Our ref: DOC20/996275

Your ref: SSD-9679

Hills of Gold Wind Farm – Environmental Impact Statement Exhibition

Hills of Gold Wind Farm – Environmental Impact Statement

**Figure 5 Location map native vegetation cover, Page 5**

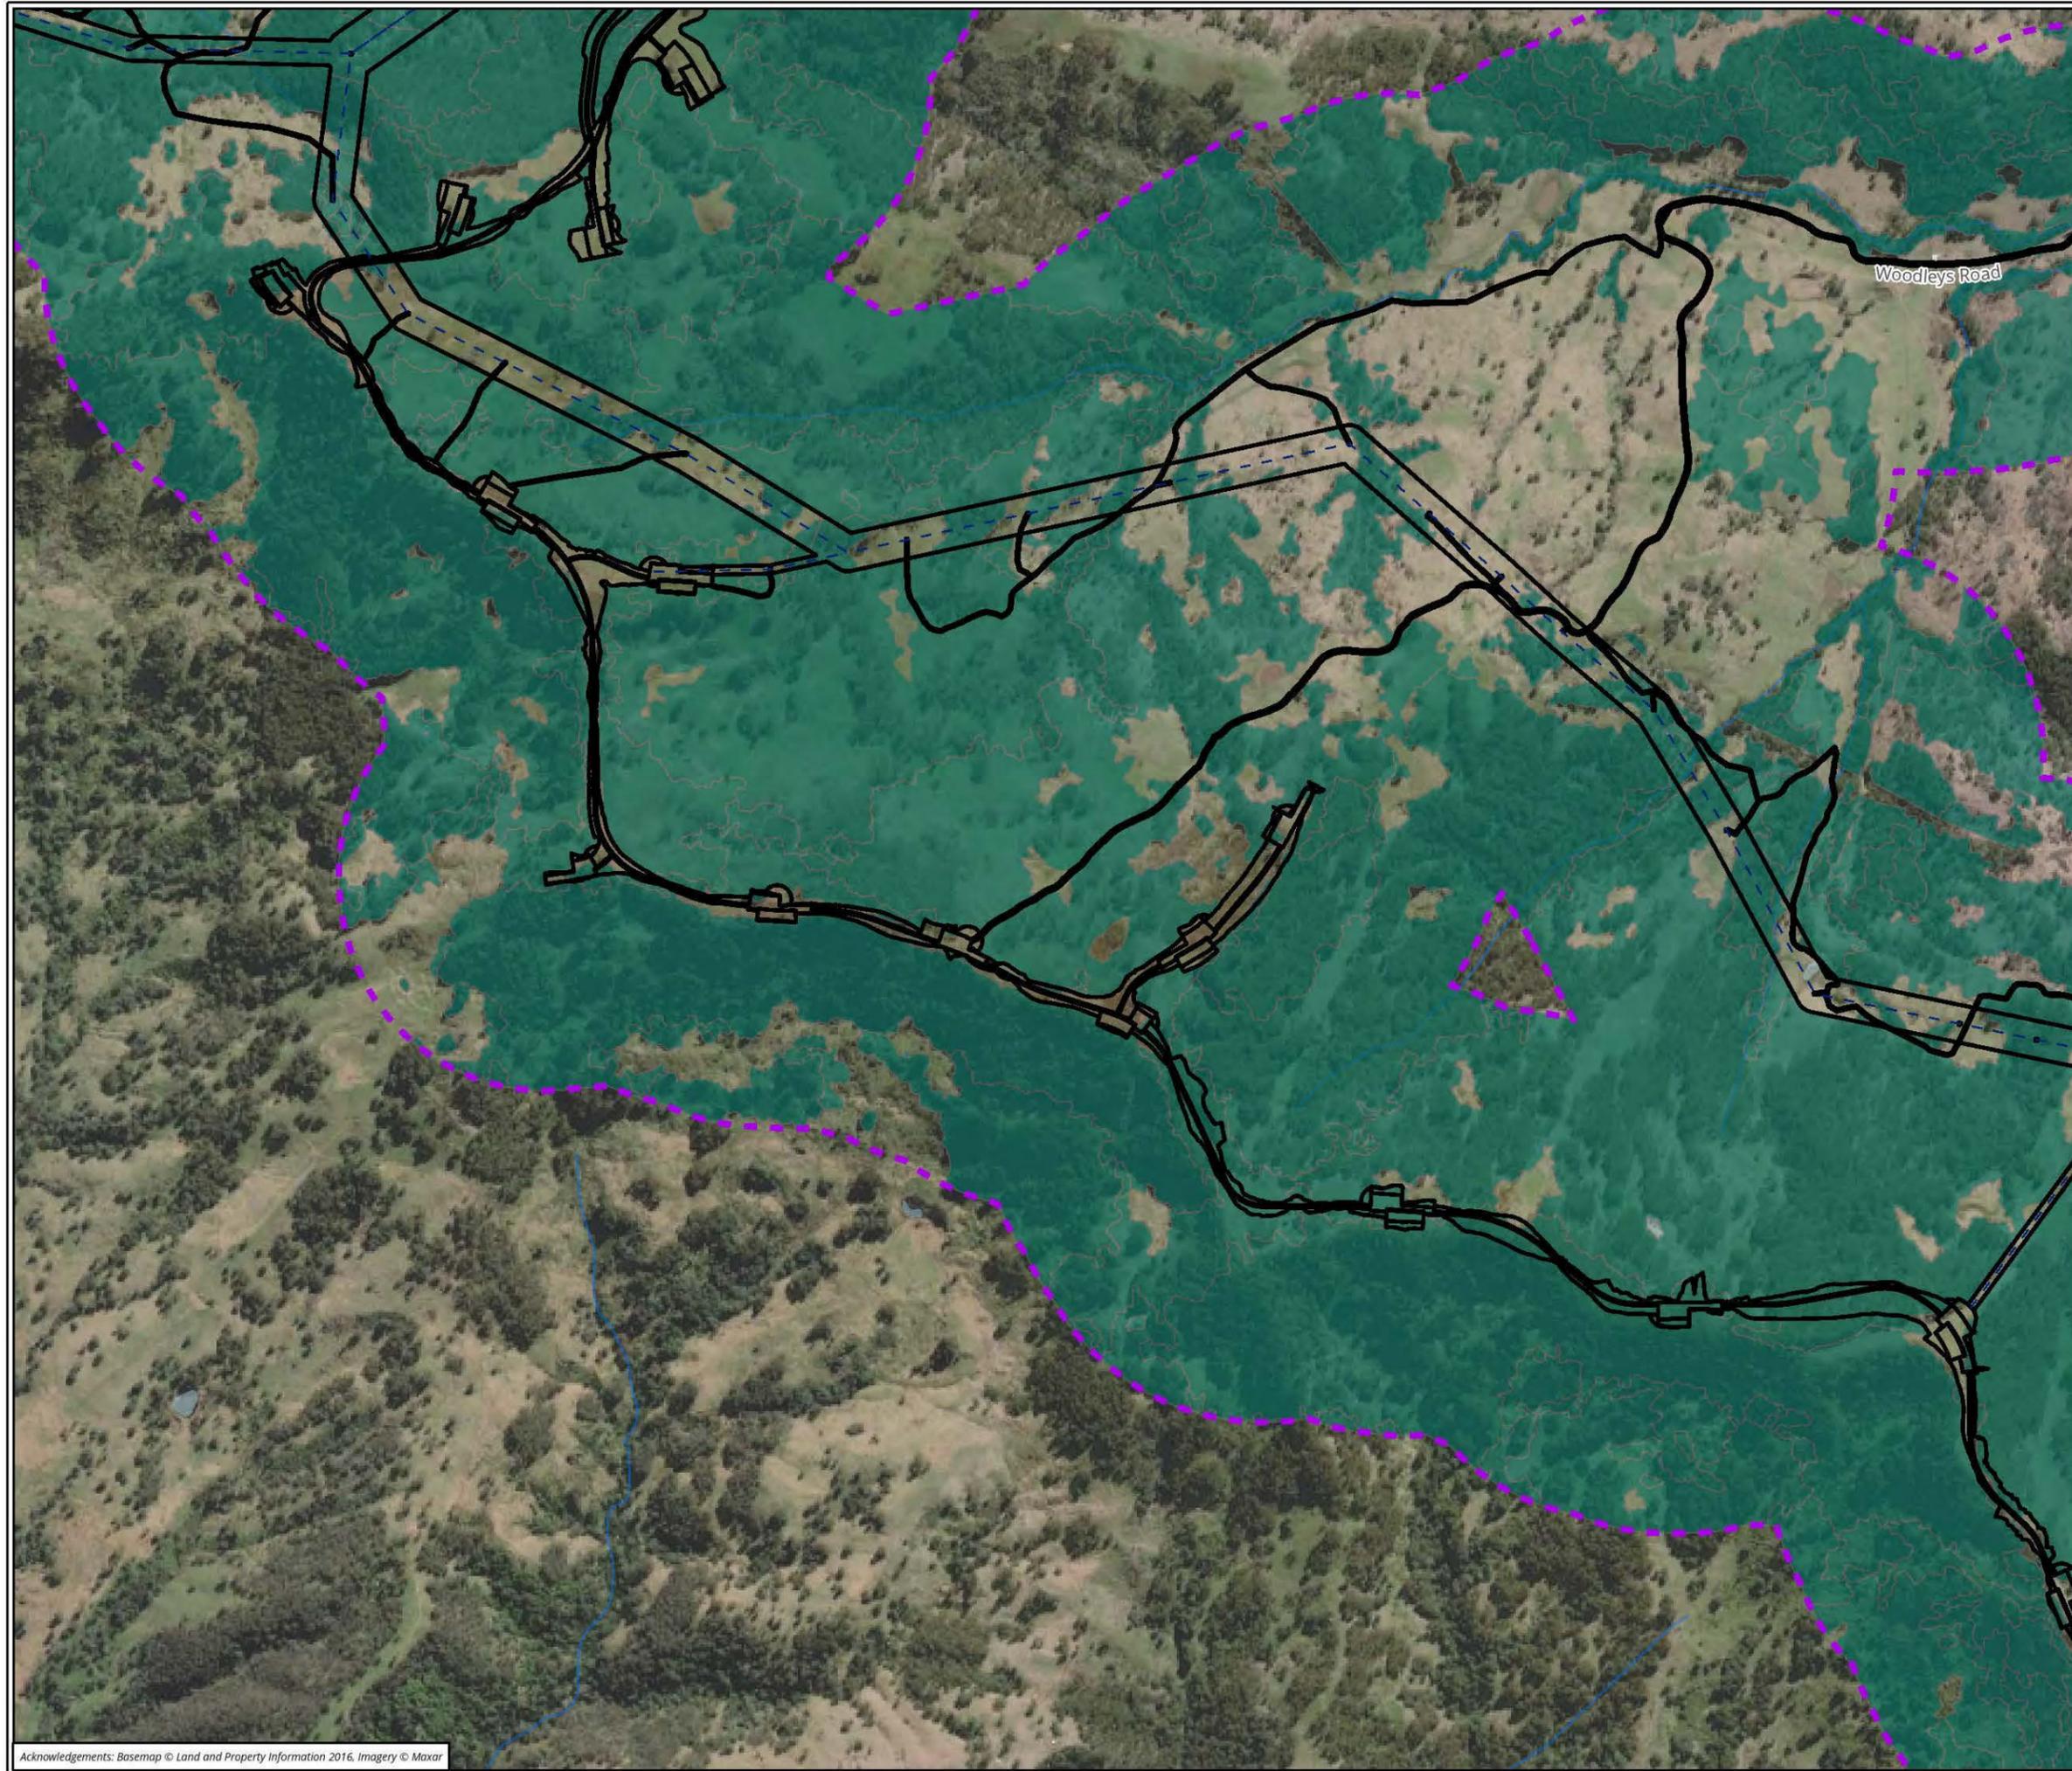
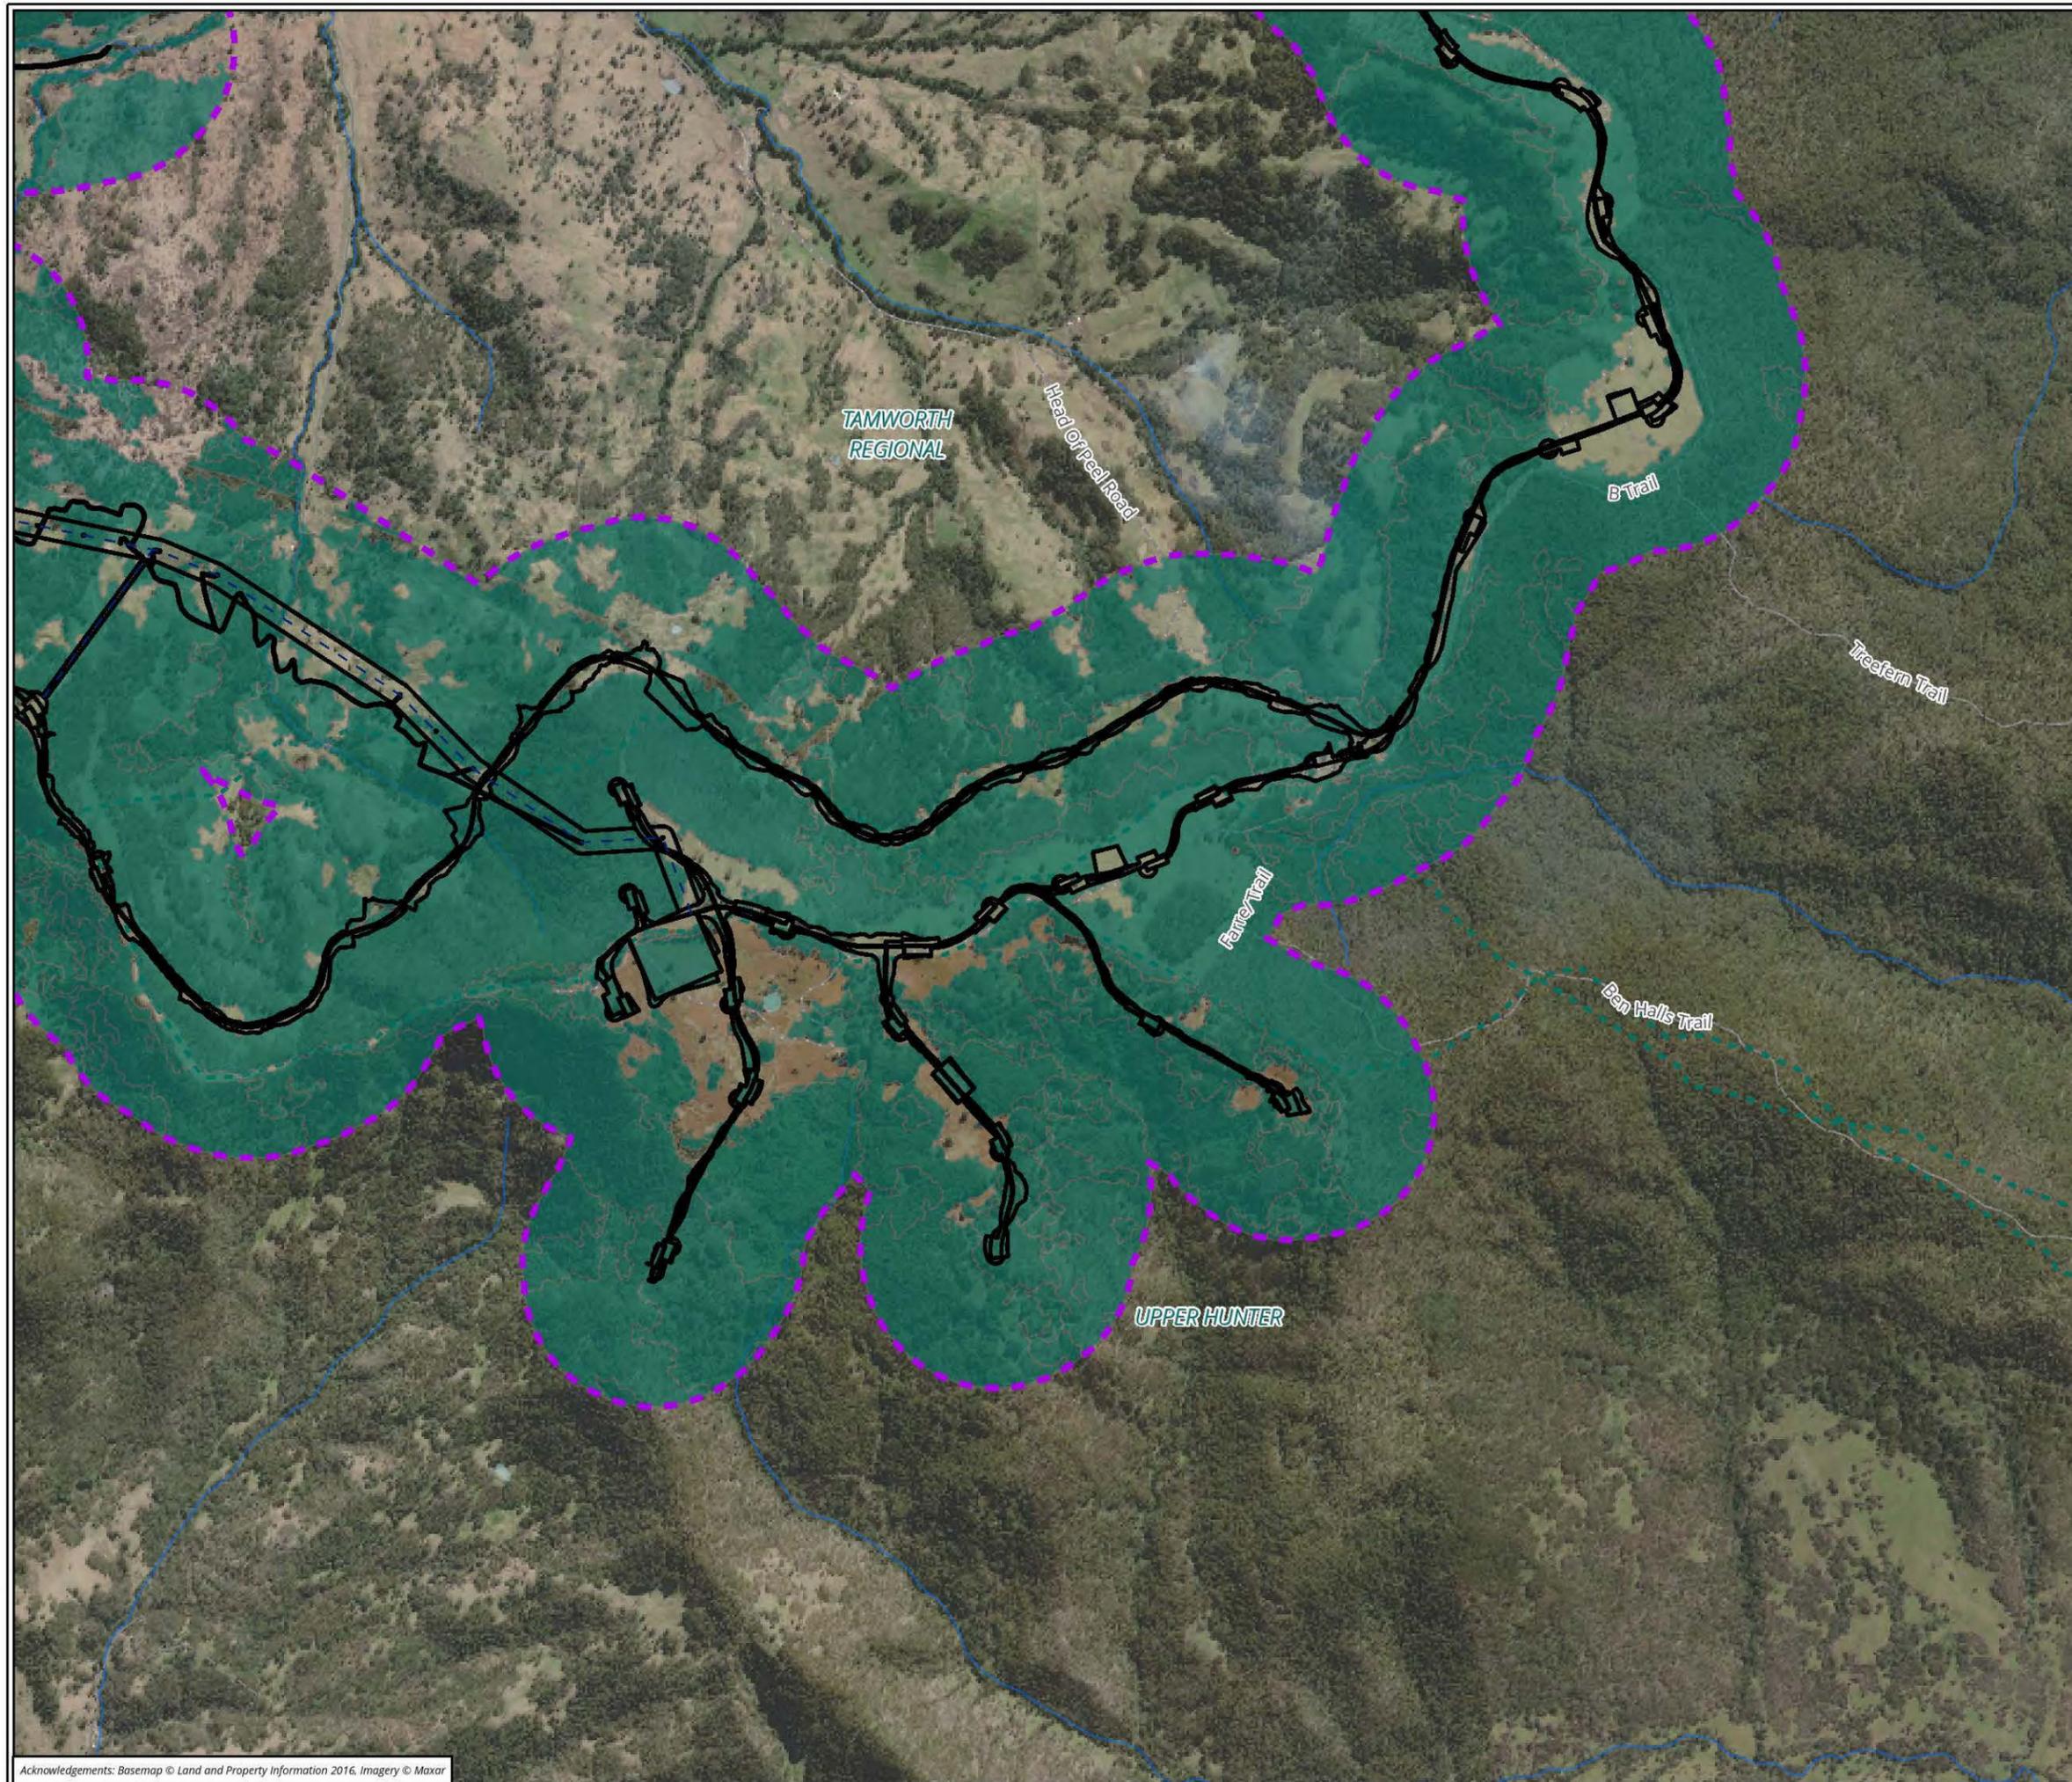
Appendix B of the BDAR provides detailed descriptions of the chosen PCTs. It is not clear whether the description, including species lists, is of the vegetation on site or a generic description of the PCT. Appendix B does not contain justification for the selection of these PCTs across the project site. While Table 11 of the BDAR provides the criteria used to assign vegetation condition classes, included exotic and planted vegetation, the BDAR provides no evidence to support these classifications that have been made and are displayed in Figure 5. Vegetation zones have not been mapped as required by the BAM.

The scale of some maps provided in the BDAR (Figure 5) makes it difficult to determine the location of the plot within the development footprint, however some plots (e.g. 1, 5, 8, 9, 21, 26) are clearly outside the footprint and therefore outside the related vegetation zones. The BAM requires plots to provide a representative assessment of the vegetation integrity of the vegetation zone. Plots must be appropriately placed within the vegetation zone and be geographically distributed throughout the project footprint. Where plots are not within the development footprint, the plot's inclusion must be justified. This should include providing evidence that the plot is in the correct PCT and that the plot data is consistent with other plot data collected in the vegetation zone. Where the inclusion of the plot cannot be adequately justified the use of benchmark data will be required.

- 3.1 Justification should be provided in the BDAR for the selection of all PCTs.
- 3.2 All vegetation zones must be clearly mapped.

- 4.1 Where vegetation plots are not located in the project footprint, justification must be provided, including evidence that the plot is in the correct PCT and vegetation zone, and that the plot data is consistent with other plot data collected in that vegetation zone.
